The following is a list of the EPC conditions from 12/25. Please see the below notes and attachments, I believe they address all your requests. I look forward to hearing your feedback.

CONDITIONS OF APPROVAL Project #: SP-2025-00091, a Site Plan – EPC, Major Amendment

SUBJECT PROPERTY:
 336 WOODWARD RD SE

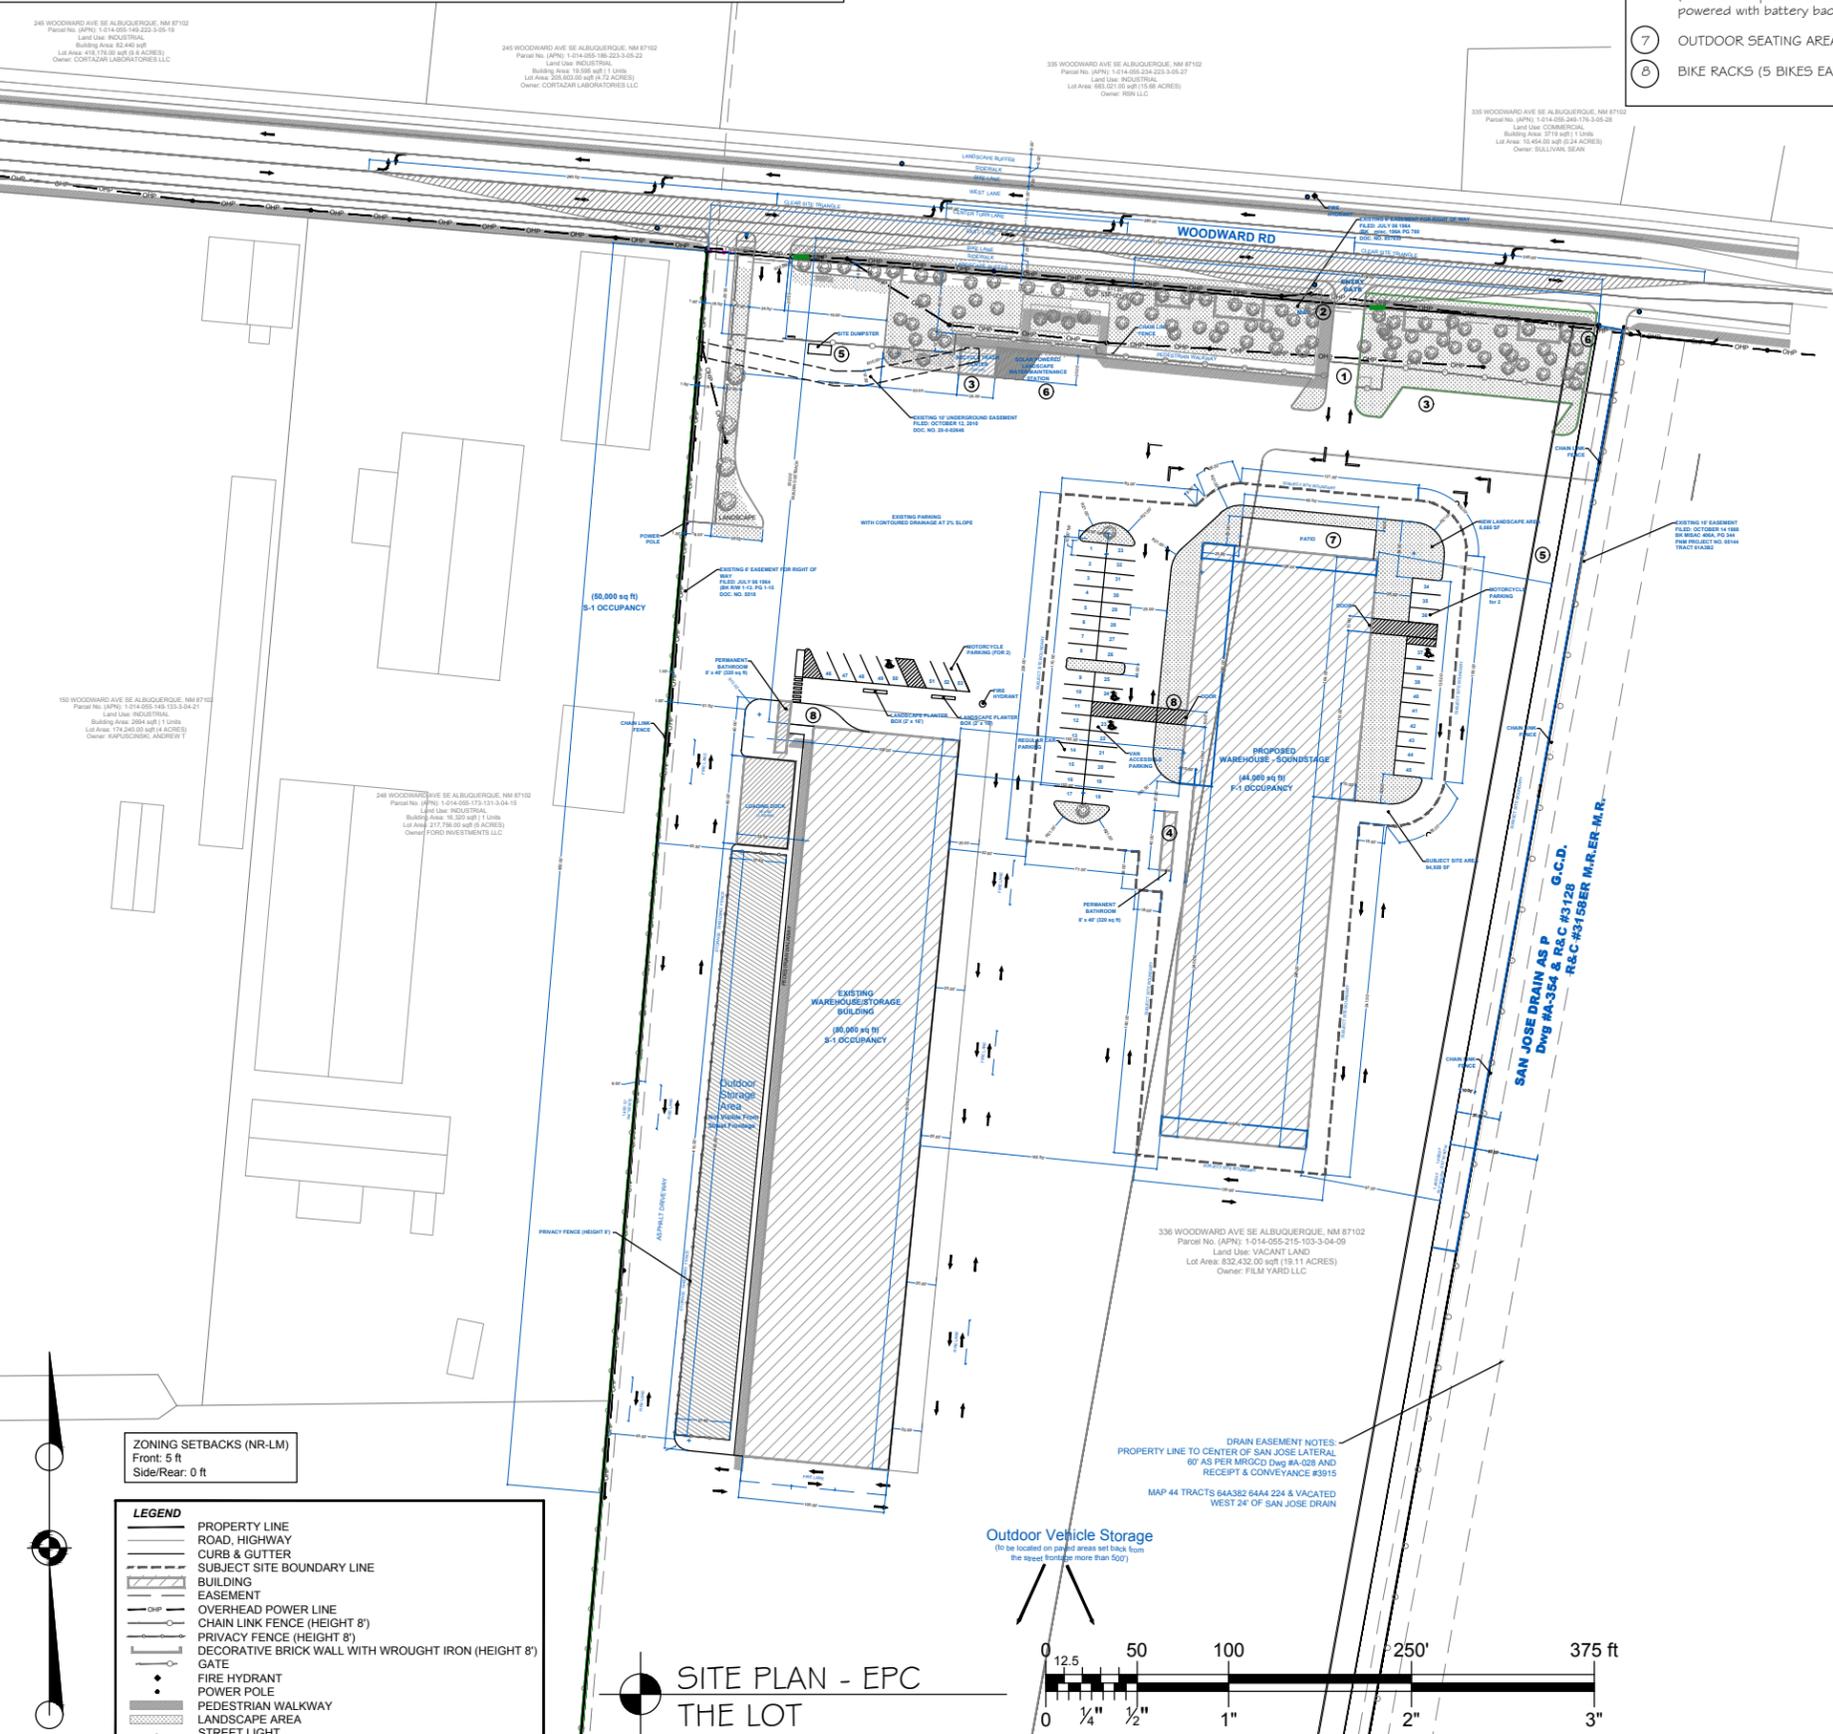
a. Update all sheets (site plan, landscaping, grading & drainage, TCL, and utility) to accurately reflect the form of developed phases on the site, including both structures, new landscaping areas, new parking areas, and outdoor storage areas.

b. All existing and planned outdoor storage areas shall be listed on the Site Plan.

c. All existing outdoor storage areas on lots 64A4 and 224 shall be called out on the Site Plan. OK

d. Outdoor Vehicle Storage shall be added to the list of allowable uses on the site plan.

1. All existing outdoor vehicle storage areas shall be called out on the site plan, including those stored on the site for loading/unloading and film production purposes. OK... we've simply relocated vehicle storage to the south portion of the lot and noted on the plan that paved parking areas set back from the road > 500' will be used for outdoor vehicle storage if necessary.

e. Parking calculations shall be updated to show total parking spaces required and provided in the subject area. OK...an updated TCL with calculations, space number, etc provided for the whole improved site.

1. Update bicycle parking calculations to reflect how many bike spaces per bike rack are provided and the total amount of individual bicycle spaces in the subject area. OK... updated throughout.

New EPC site plan, TCL, G&D, and landscaping plans attached. Also drawings moved to separate sheets for landscaping, TCL and the main plan.

1. Any fences and screening of these outdoor storage areas should be included on the site plan and detail sheet. OK

Landscape Plan (Overall)
Phase 1 and 2

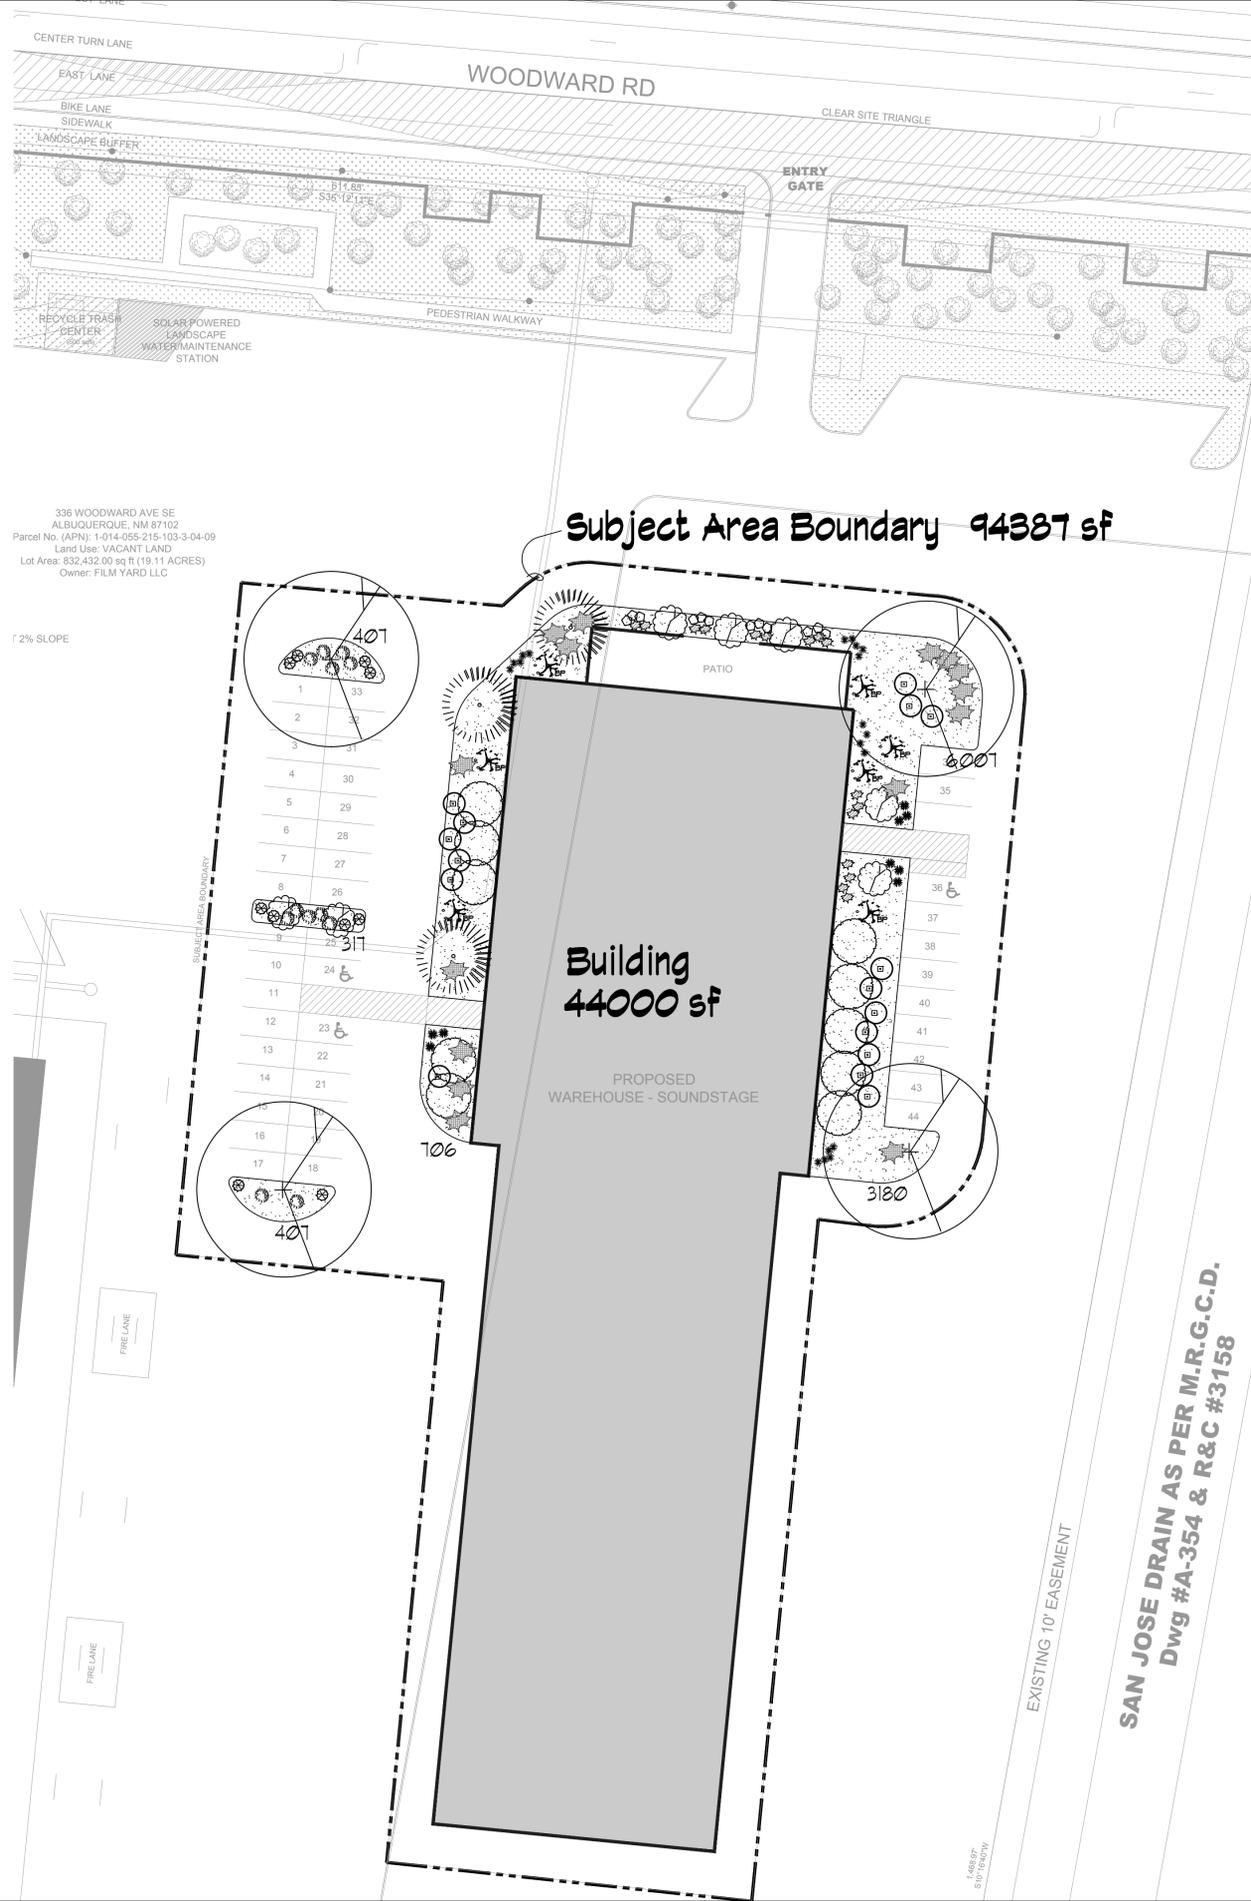
6. Landscaping Plan: Provide an additional, new overall Landscape Plan sheet (of both Phase 1 and 2) that shows the landscaping, calculations and landscape legend for the subject area. Provided, plus phase I by itself and phase II by itself, and detail sheets... provided

Mitchell Associates, Inc
Landscape Architect
DANNY D. MITCHELL
239
REGISTERED LANDSCAPE ARCHITECT
Dec. 4, 2025
Copyright 2025, Mitchell Associates Inc.
PROJECT NO: 2024-055
DRAWING NO: **LS-101**

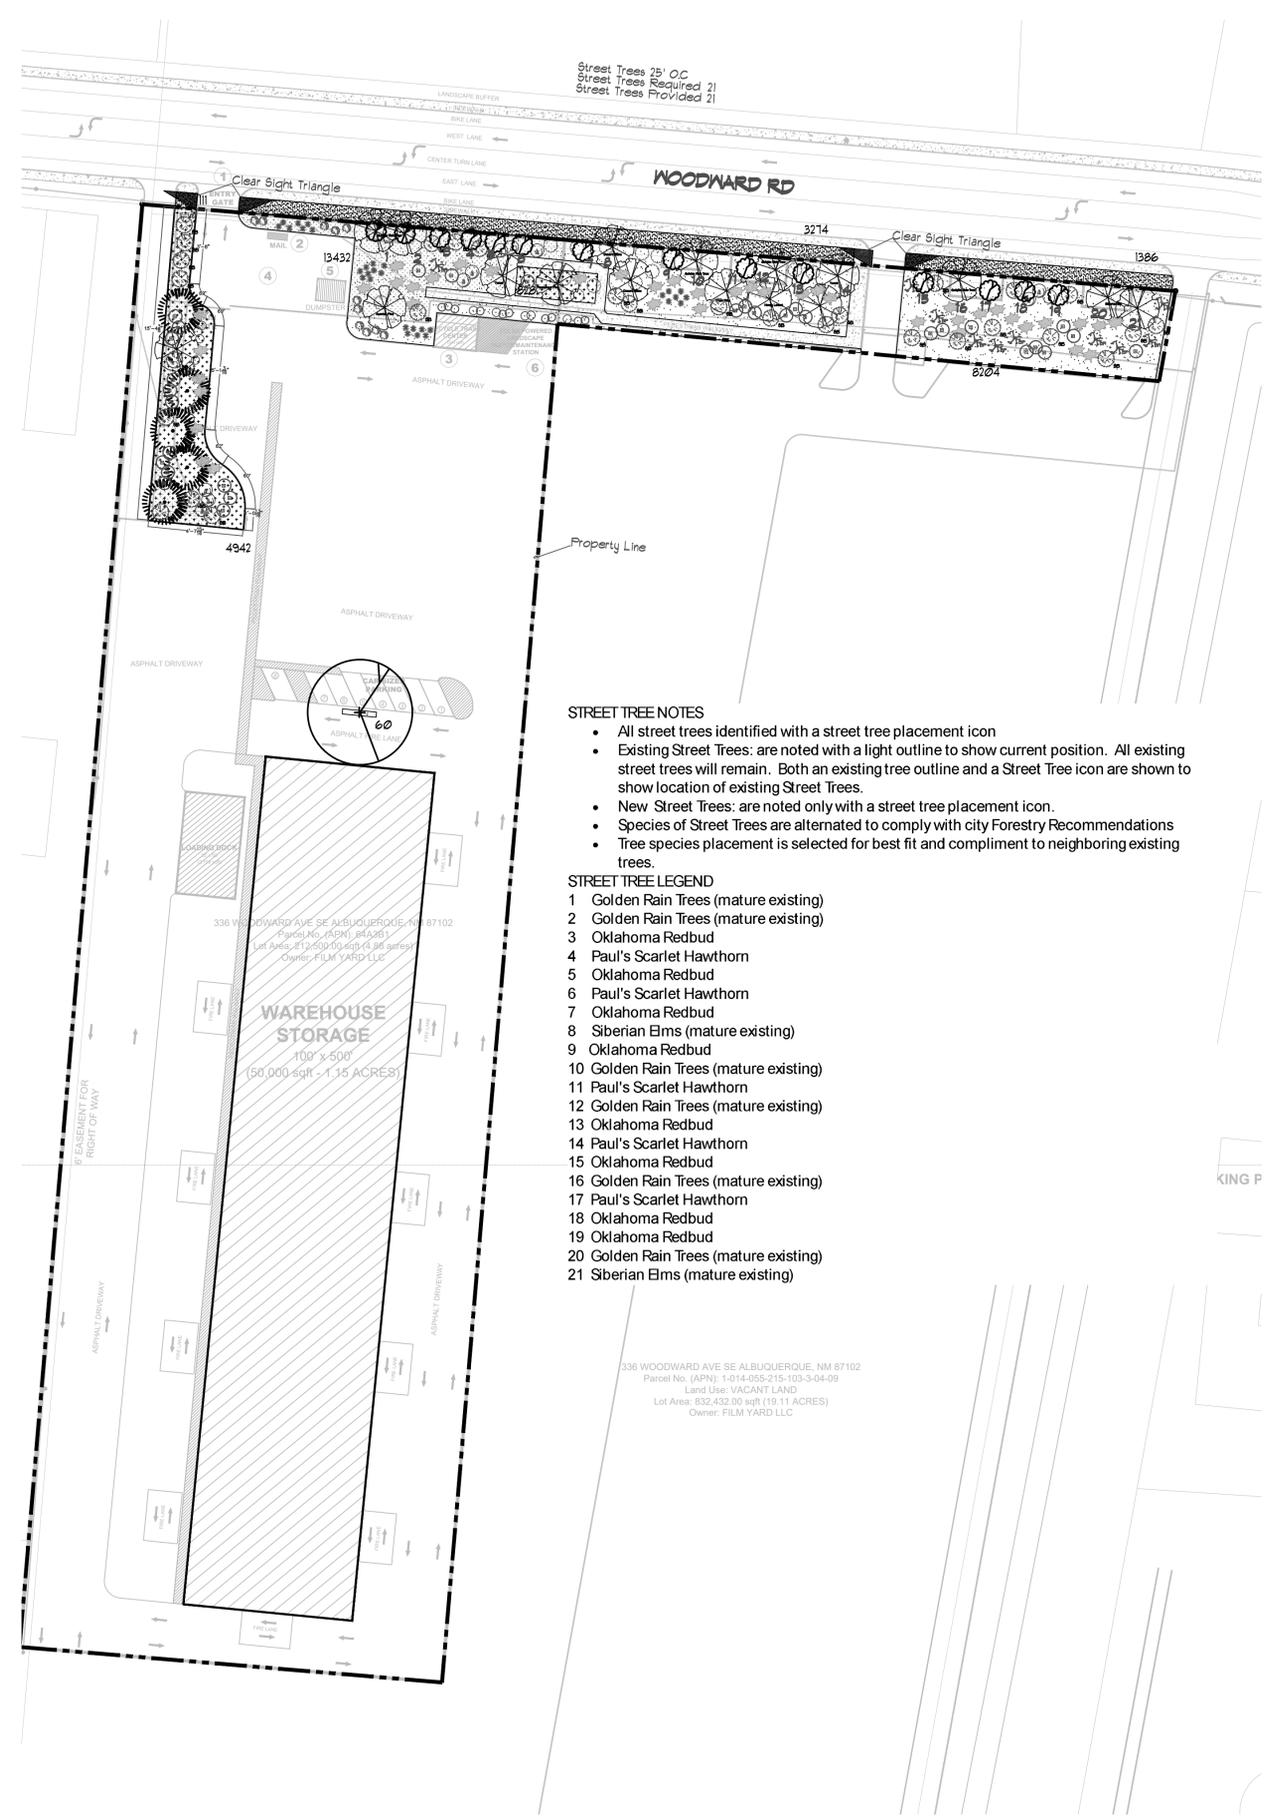
1. Landscaping sheet LS-101 shall remain the landscaping sheet for the current subject area of this request. • Update Total Tree and Total Shrub calculations to accurately reflect the total amount of trees and shrubs that are on this sheet. OK
